From: Martyn White
Sent: 08 July 2019 11:38
To: Planning.Responses <Planning.Responses@arun.gov.uk>
Cc: Anita Gardner <Anita.Gardner@arun.gov.uk>
Subject: AB/50/19/PL

AB/50/19/PL

Proposed part change of use (Class C3a) to form a single residential unit from two existing separate buildings. One building currently mixed use (part C3a & part A1) & the other residential (class C3a). Limited external works demolition boundary wall & external stairway

**PROPOSED
ELEVATIONS**

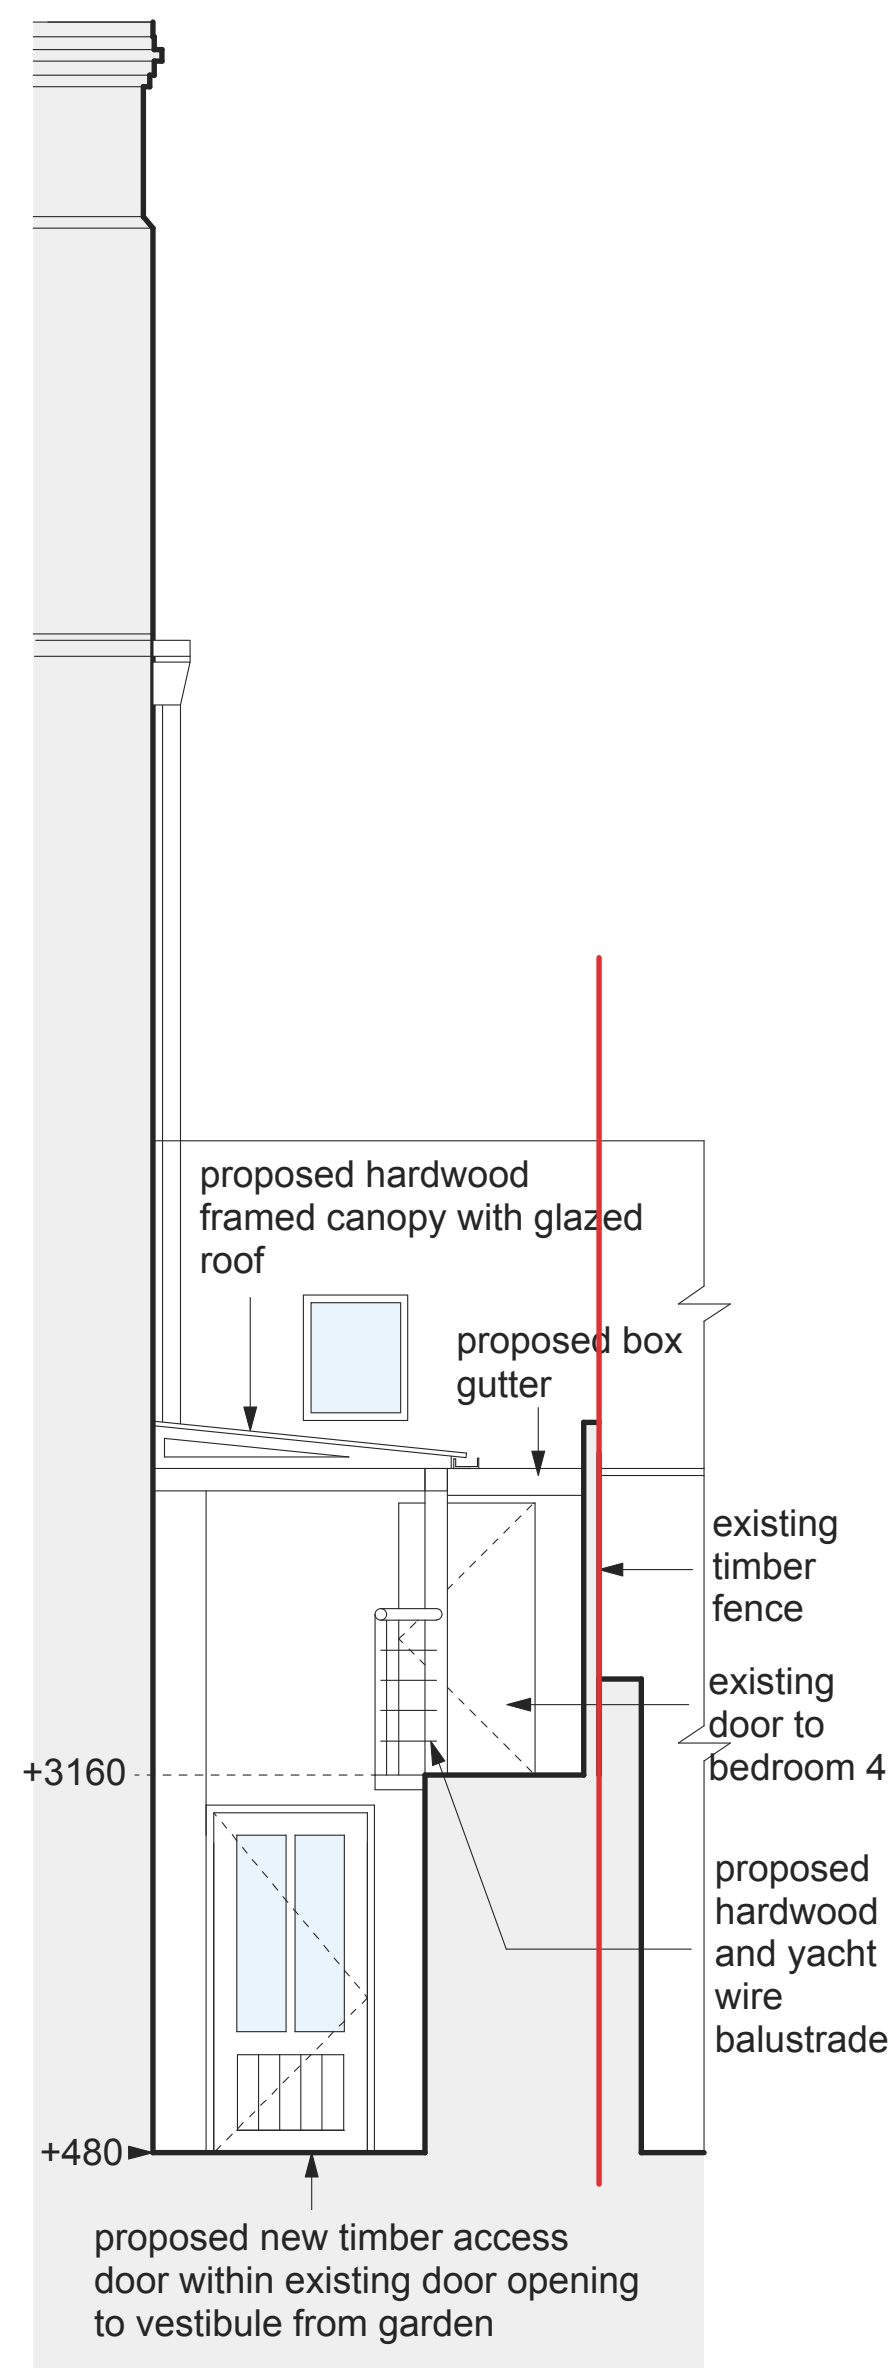
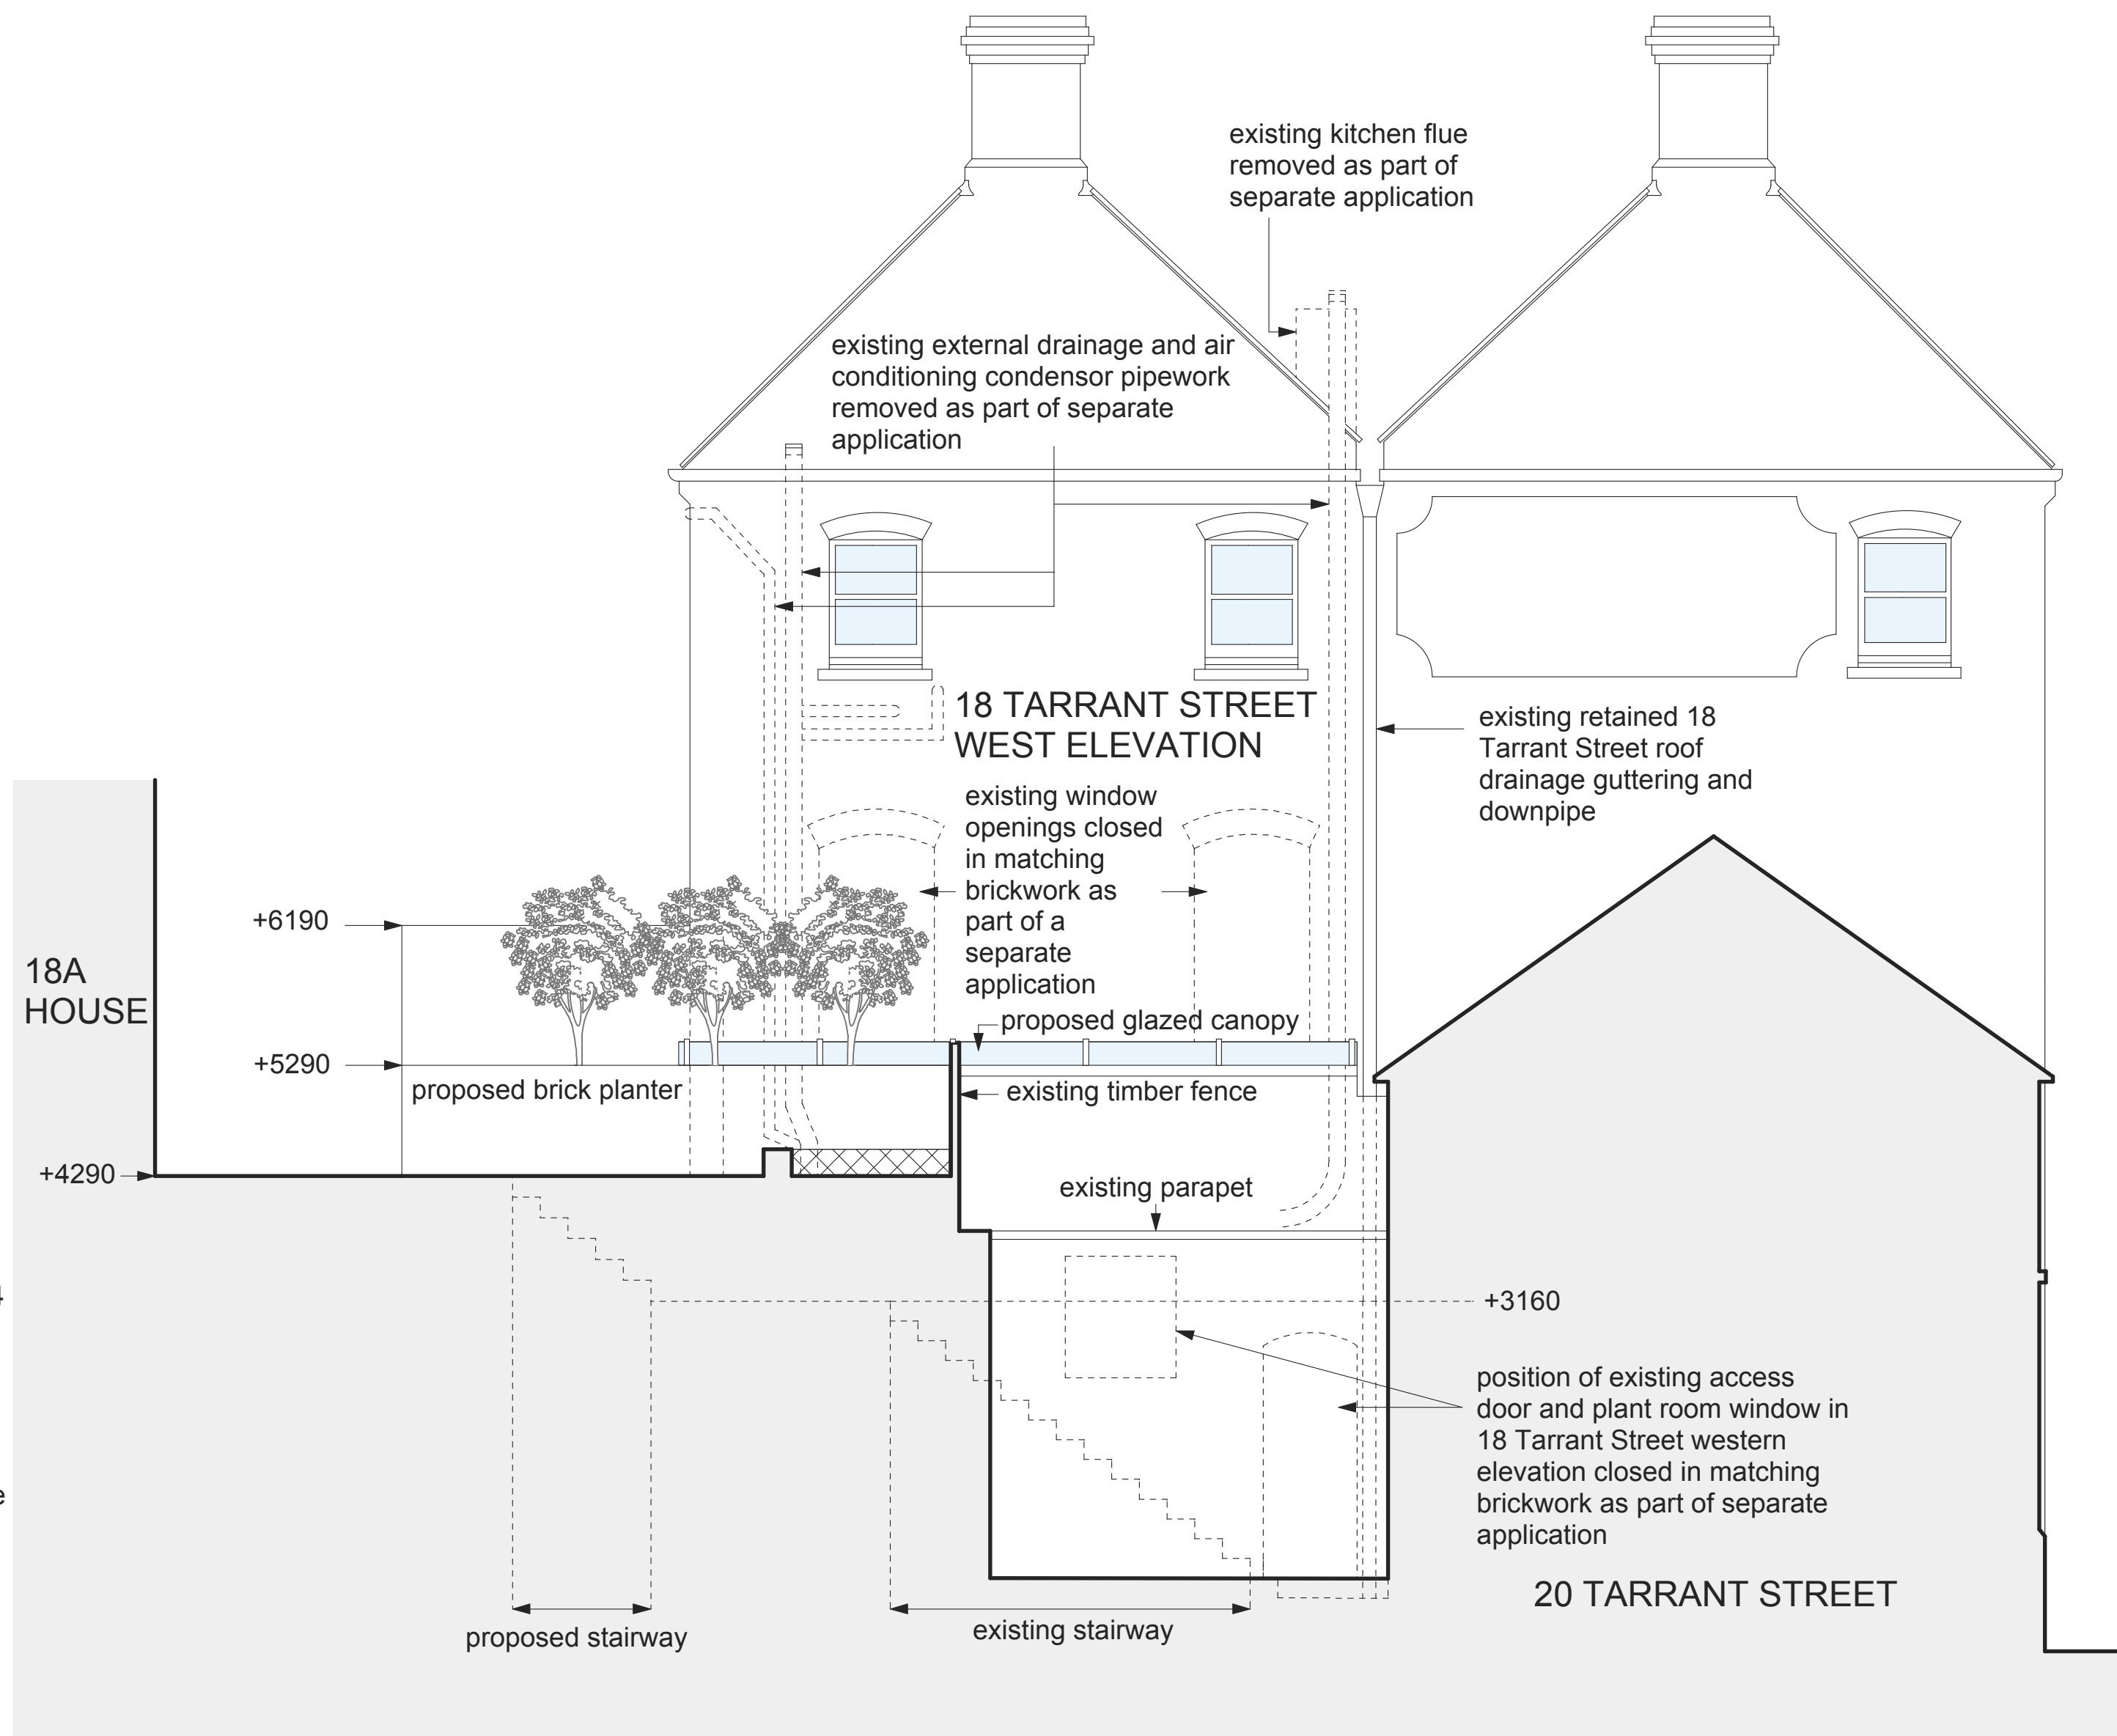
The concept of the canopy seems to be acceptable. It is considered that further detail are provided regarding its appearance in order to ensure that it fully reflect the character of the listed building. As the canopy is attached to the neighbouring listed building, would this require the submission of a listed building consent?

Whilst this is unfortunate, it is acknowledged that the reason behind this is to ensure that a suitable use will be achieved for the property. It is suggested that the proposed brickwork which would be used to infill the windows/door should be slightly recessed so that the former openings can be read and understood as a development of the building. All brickwork and mortar should match the existing in terms of appearance and bond. It is suggested that the bricks removed to create a new opening for the new main entrance could potentially be used for this purpose, if considered to be suitable/match those used in the elevation.

The proposed new opening is considered to be acceptable as the amount of historic fabric to be removed is minimal and will not affect the significance of the building. It is suggested that these bricks are retained and used on the eastern elevation where existing openings are to be blocked up. The design of the door will need to be approved by the LPA.

Any new other brickwork should match existing in terms of colour, appearance, bond and mortar.
